March 7th, 2023

PA23-003 - Response to City of Marysville comments
7728 & 7808 47th Ave NE – APN 30052100412500 / 30052100414500

Site Plan review comments:

JENNINGS PARK SUBSTATION
SITE PLAN FOR GRADING PERMIT

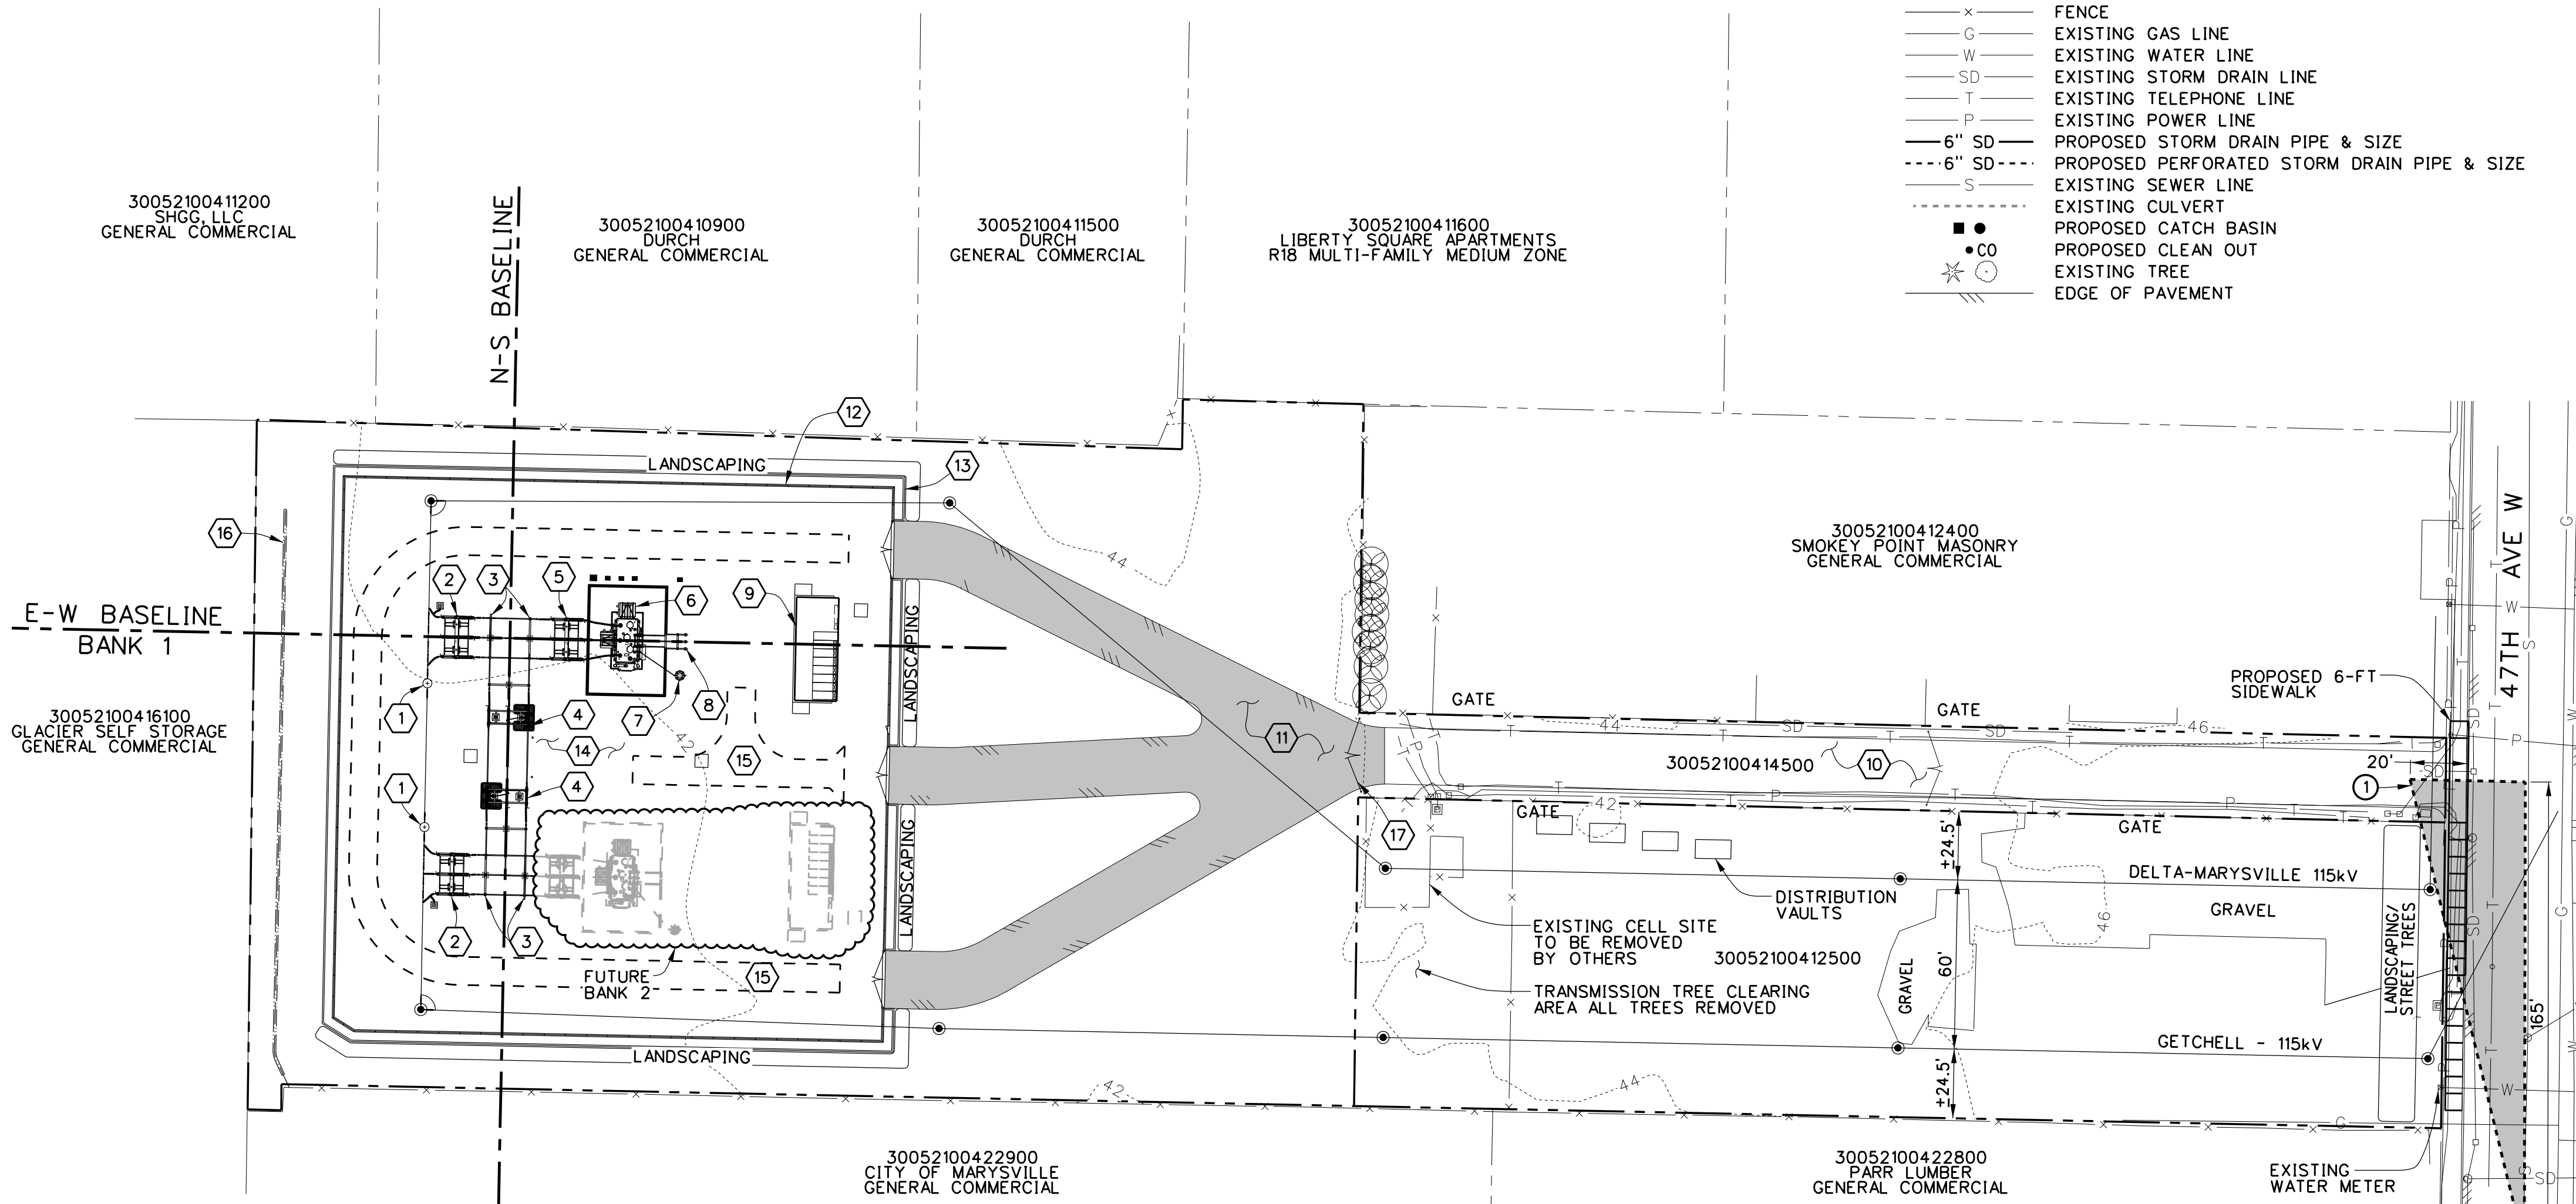
3. Frontage Improvements: Frontage improvements are required per MMC 12.02A.090 on all projects. Frontage improvements are described as curbs, gutters, and sidewalks; underground storm drainage facilities; patching the street from its preexisting edge to the new curb line; and overlayment of the existing public street to its centerline.

- a. The existing access for the home should be removed and the curb replaced. It would appear that because of ownership the project could gain access via the existing driveway on parcel 30052100414500. As the sidewalk is adjacent to the curb the sidewalks should also be replaced with a 6 foot sidewalk. The project is proposing the requested 6 foot sidewalk.

- a. The proposed access appears to align with the roadway across the street, there is an existing access on parcel 30052100414500 which should be utilized if possible. The use of the proposed access can be approved provided that there are no objections from the Traffic Engineer.

c. The maximum allowed impervious surface coverage for the Zoning designation is 85%.

Confirmed – our submitted plans reflect these comments curb/gutter and sidewalk will be replaced across the frontage as part of this project.

The existing access from parcel 30052100414500 will be used as noted above. This access is not only for use by the District but the business to the north holds easement on this area for access. Termination of this access would interfere with their operations as well.

So noted.
